Application for DCO by FOSSE GREEN
Representation by Interested Party reference F88728215
Deadline 6

Summary of Submissions

A Comments on REP5A-038- Applicant's Response to Deadline 5 submissions:-

EN010154/APP/6.2.

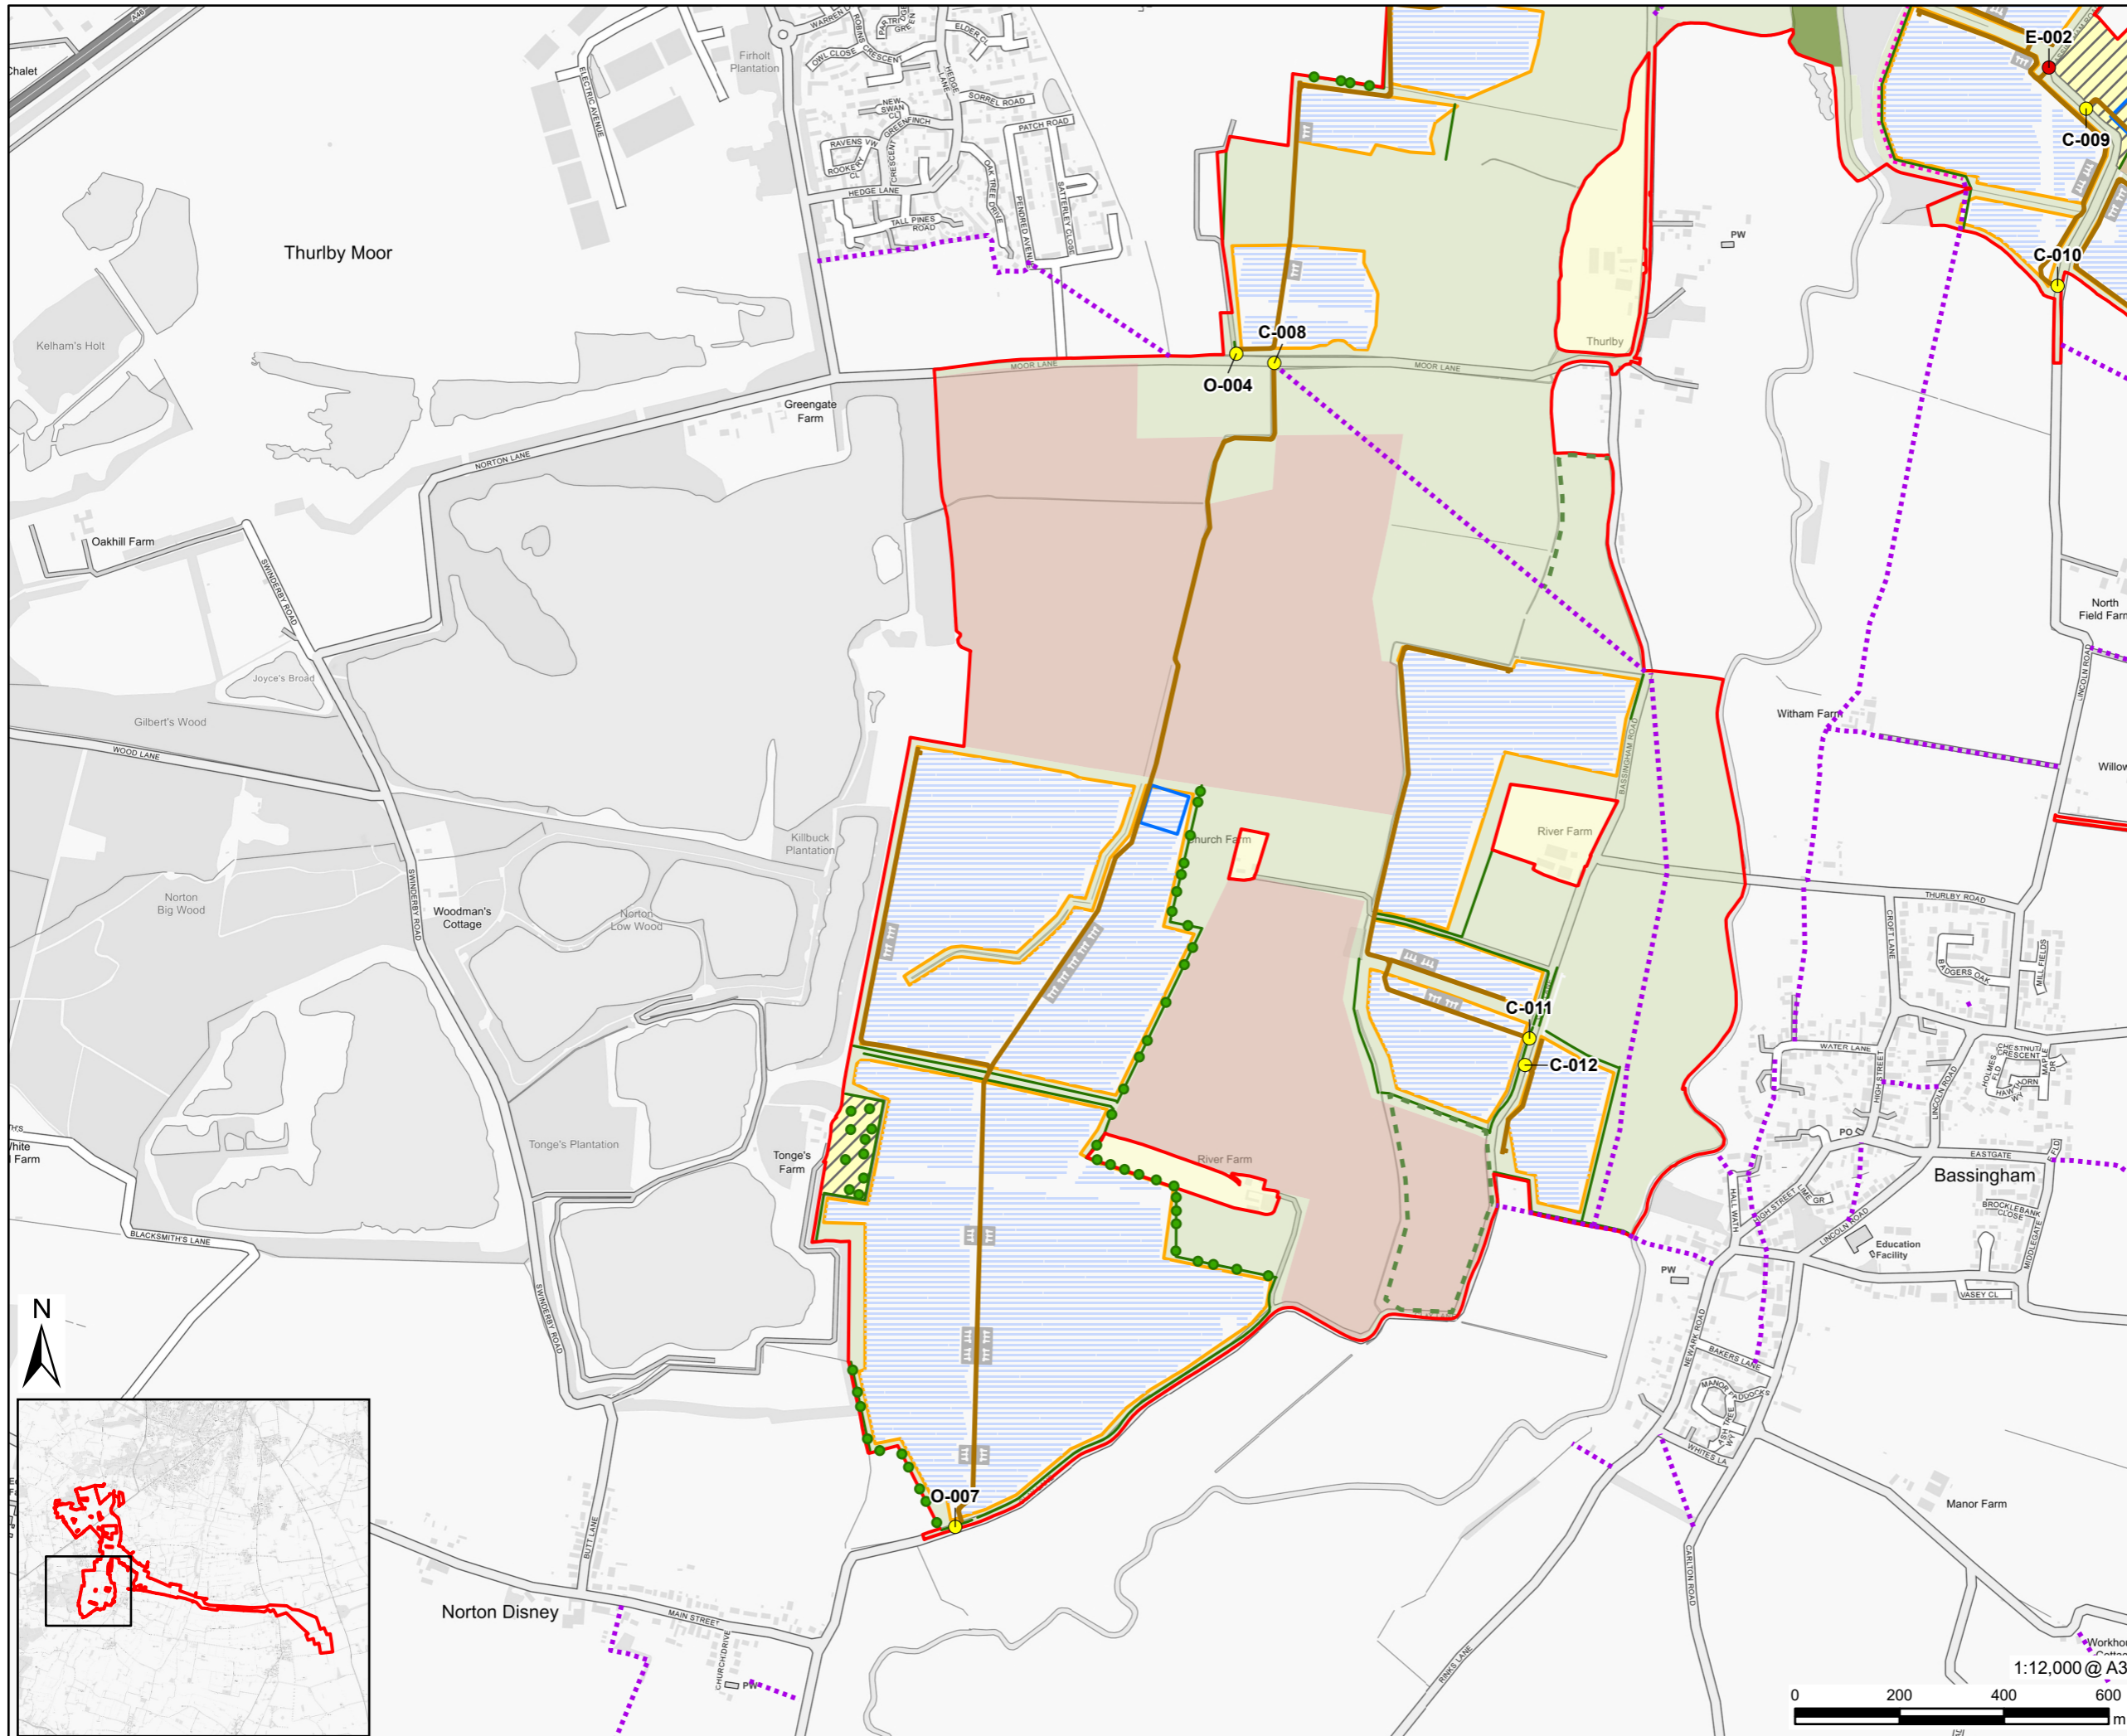
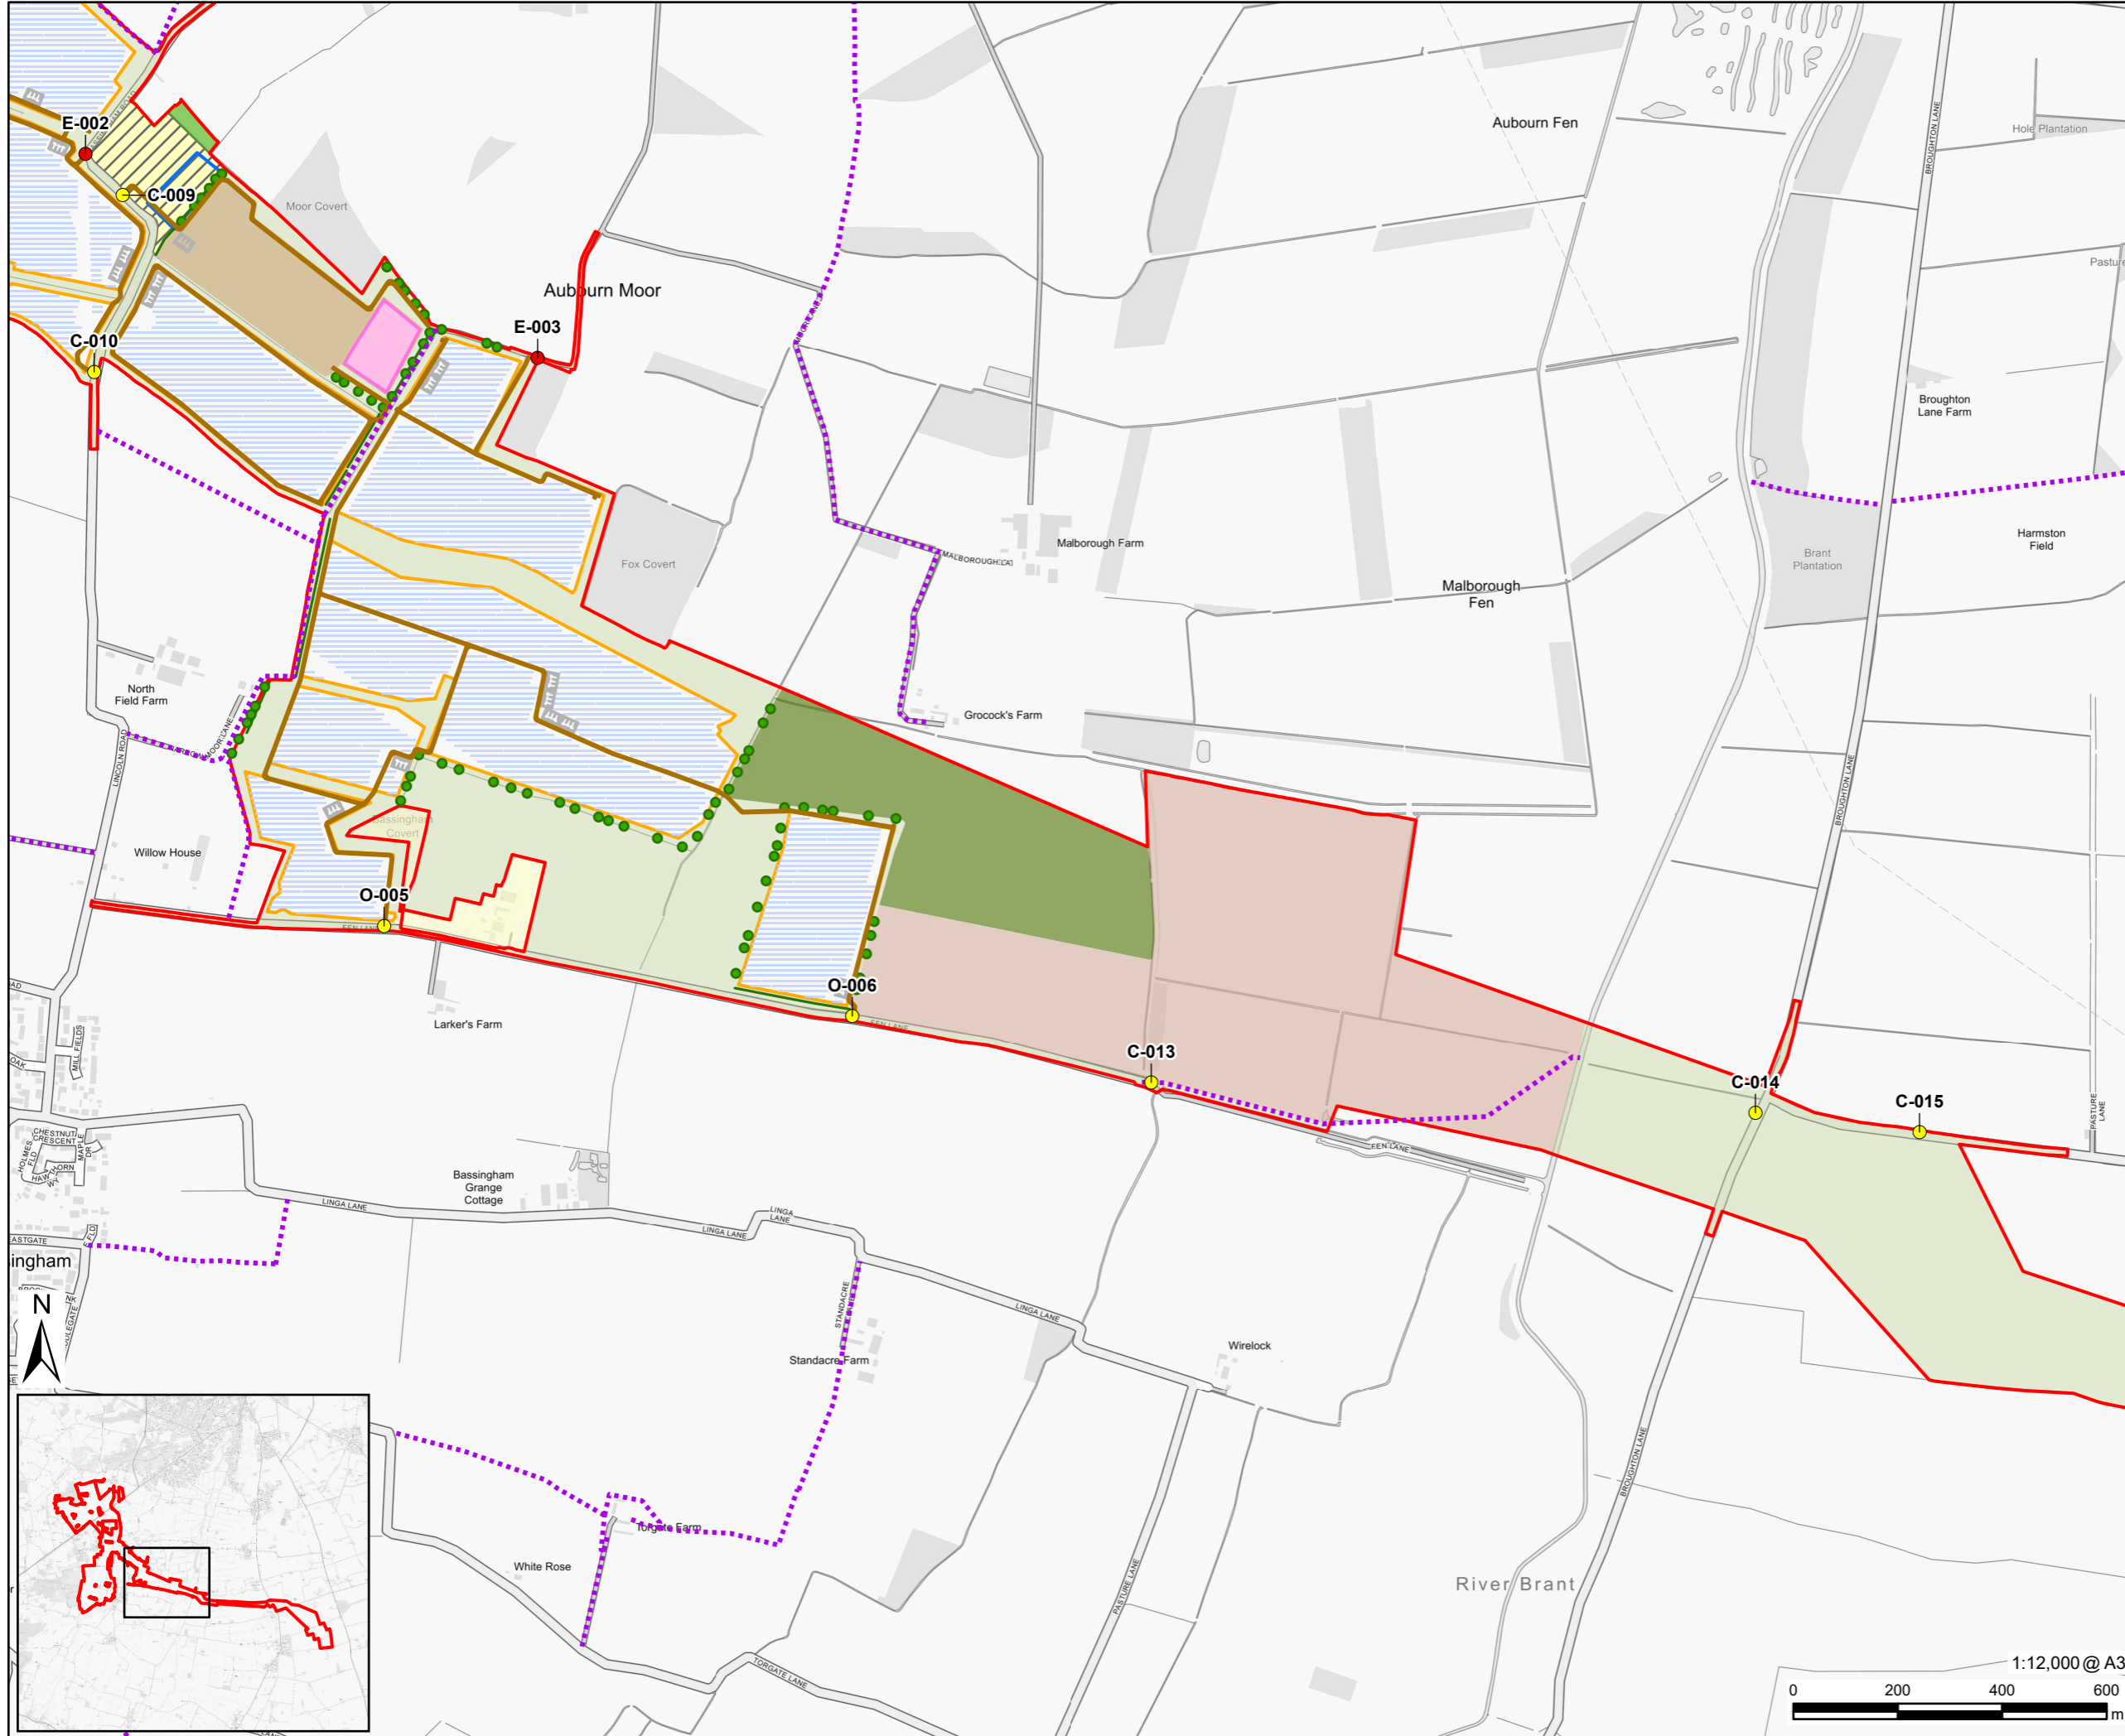
7.2.1 Whilst the Indicative Fixed South Facing Site Layout Plan (REP5-006) and Figure 3-2B Indicative Single Axis Tracker Site Layout Plan (REP5-007) are indicative, it would surely not have been too difficult to show the location of the route of the permissive path so as to be consistent with other plans. Whilst those indicative plans show the permissive path within the highway and the Streets, Rights of Way and Access Plans (REP-004) show the permissive path to the west of the highway, there is a further version shown on the FLEMP Appendix A Figure 7.15.1 (REP5-017) Sheet 9 which shows the permissive path partially within the highway and partially to the west. Three different versions of the route of this path!

Figure 3-2A Indicative Fixed South Facing Site Layout Plan (REP5-006) and Figure 3-2B Indicative Single Axis Tracker Site Layout Plan (REP5-007) are indicative whilst the Streets, Rights of Way and Access Plans (REP5-004) are detailed secured plan showing the proposed permissive path at Clay Lane adjoining the western edge of the highway.
